**Consultation Response from Mike Hibbert,
KC Waste Strategy(Refuse & Recycling)**

2023/91212 Land off, Bankfield Drive, Holmbridge, Holmfirth, HD9 2PH

Erection of 21 dwellings with access from Laithe Avenue

Responding Ref: WPS 23-057

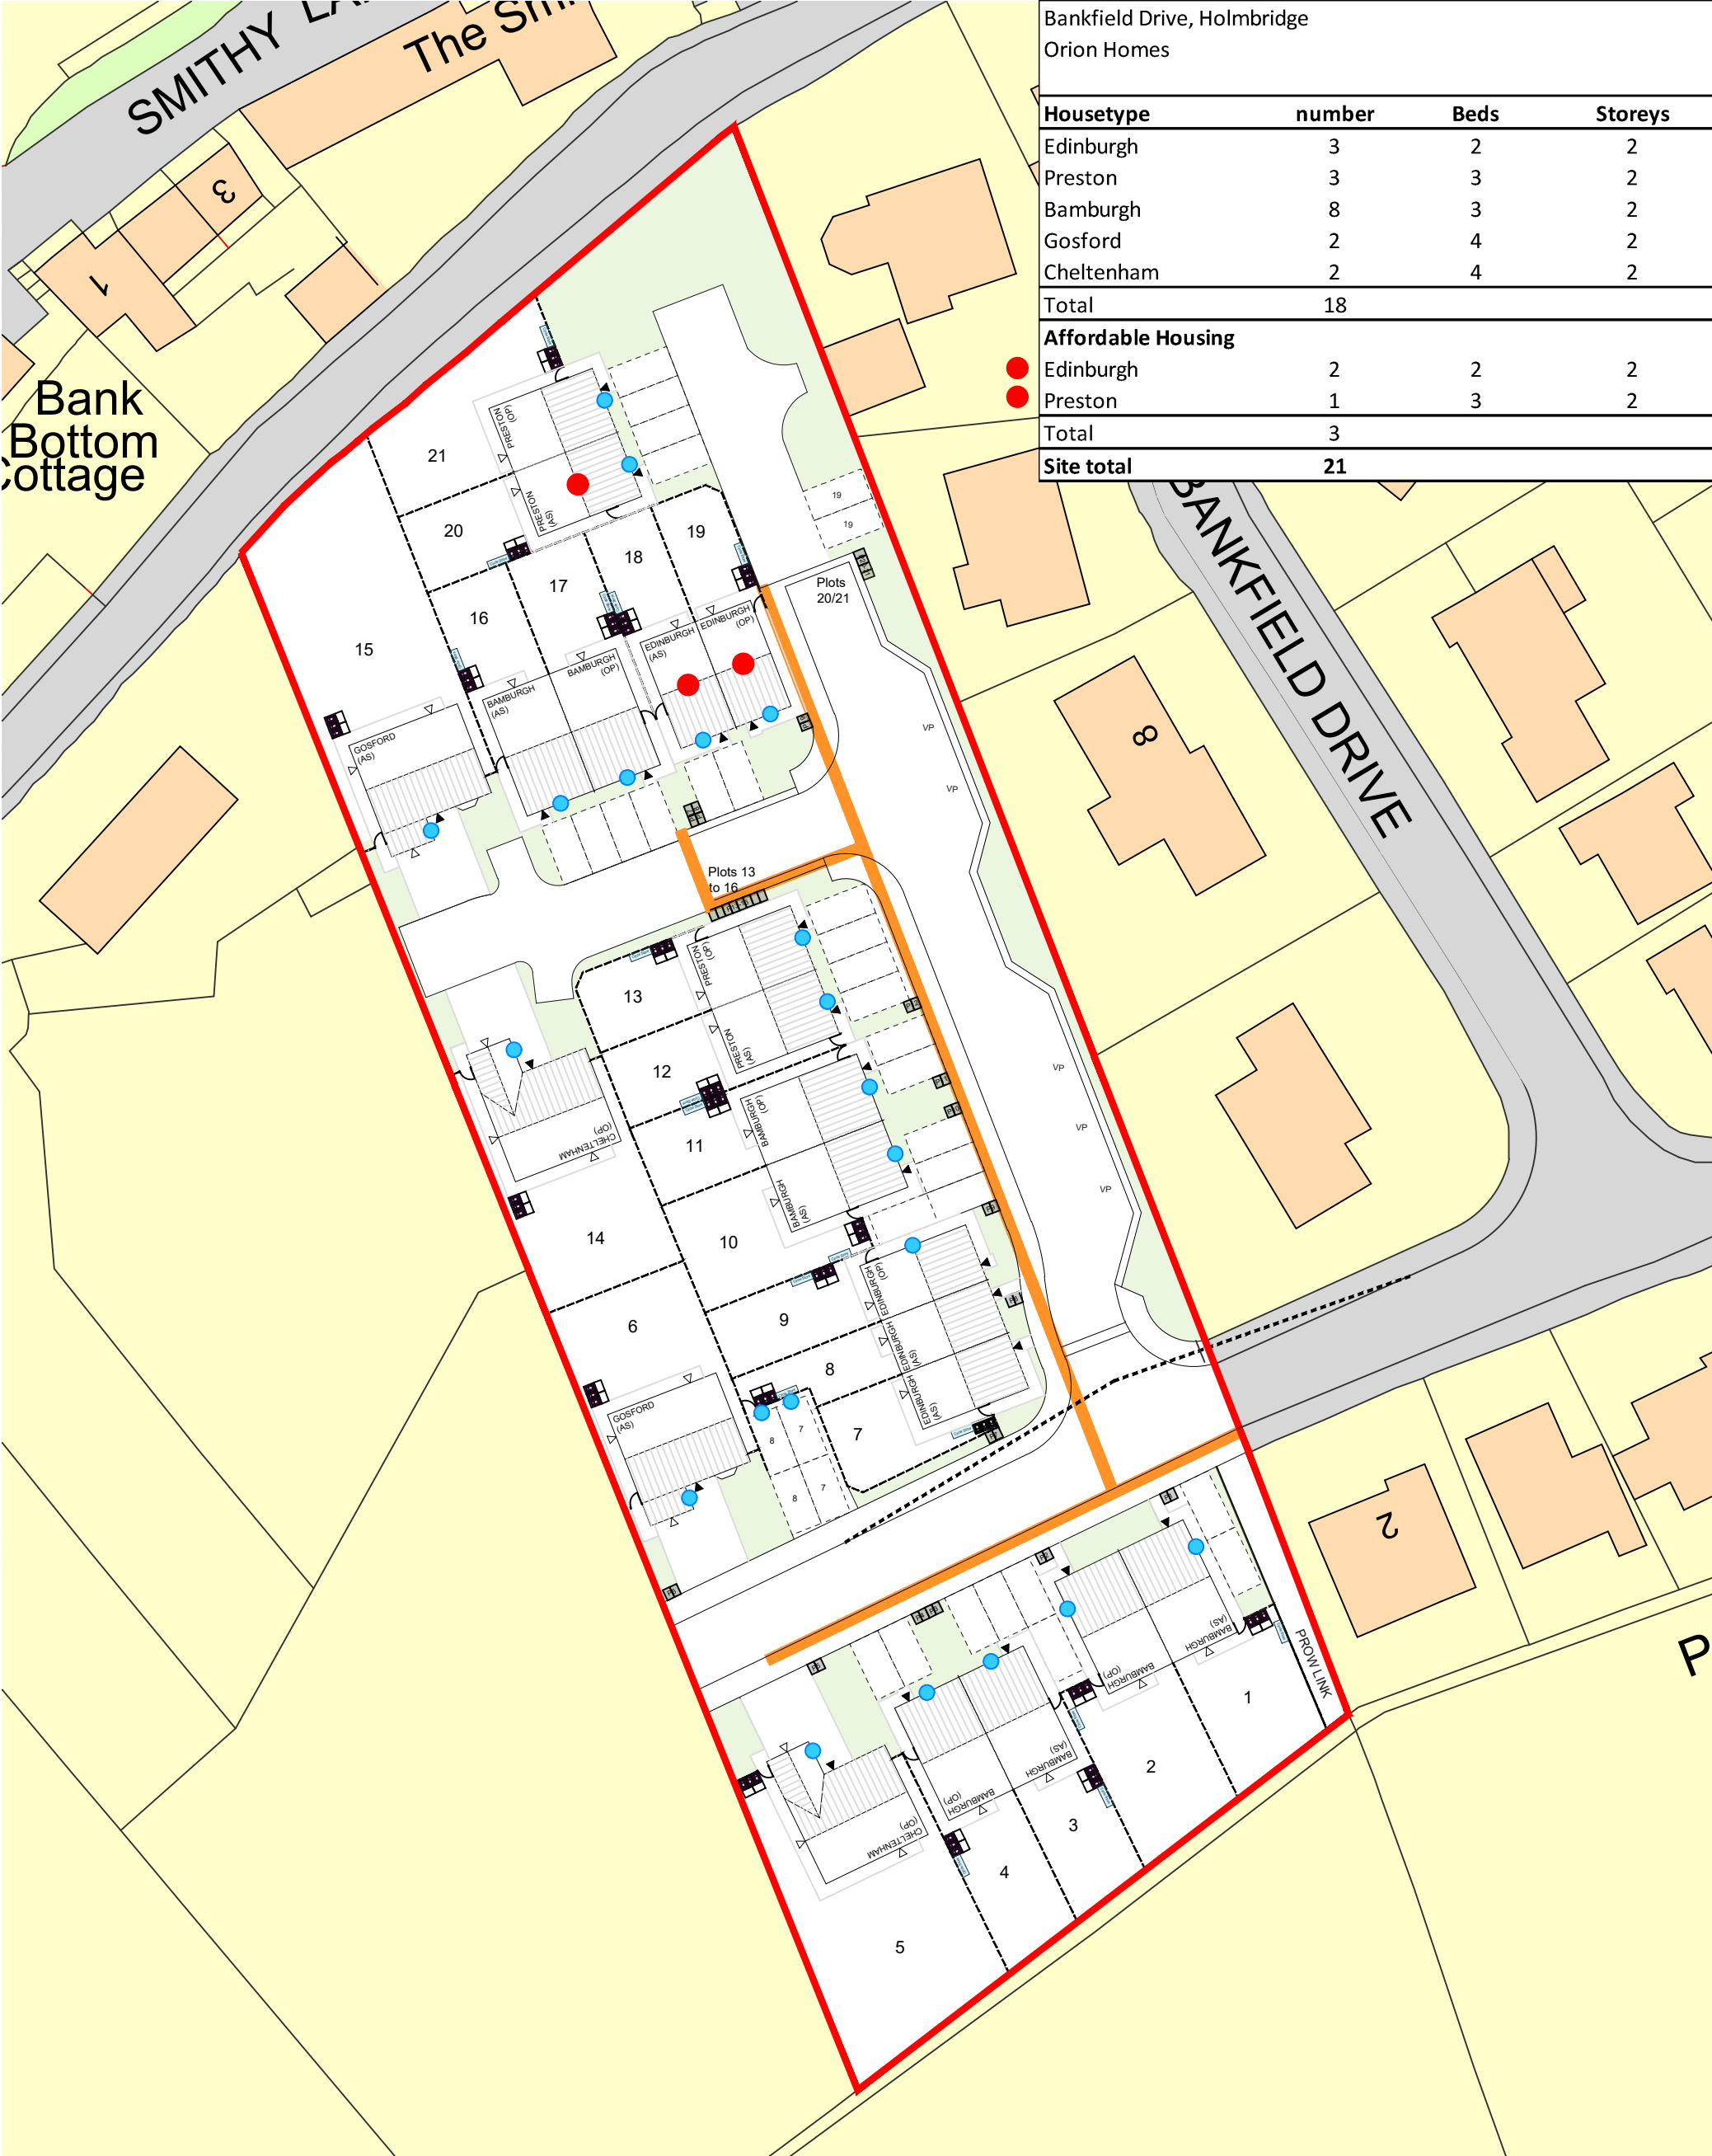
The applicant has submitted Dwg 2021.01.003 Rev V dated 3/10/2023.

The additional information supplied on the plan satisfactorily addresses the points raised in consultation WPS 23-02.
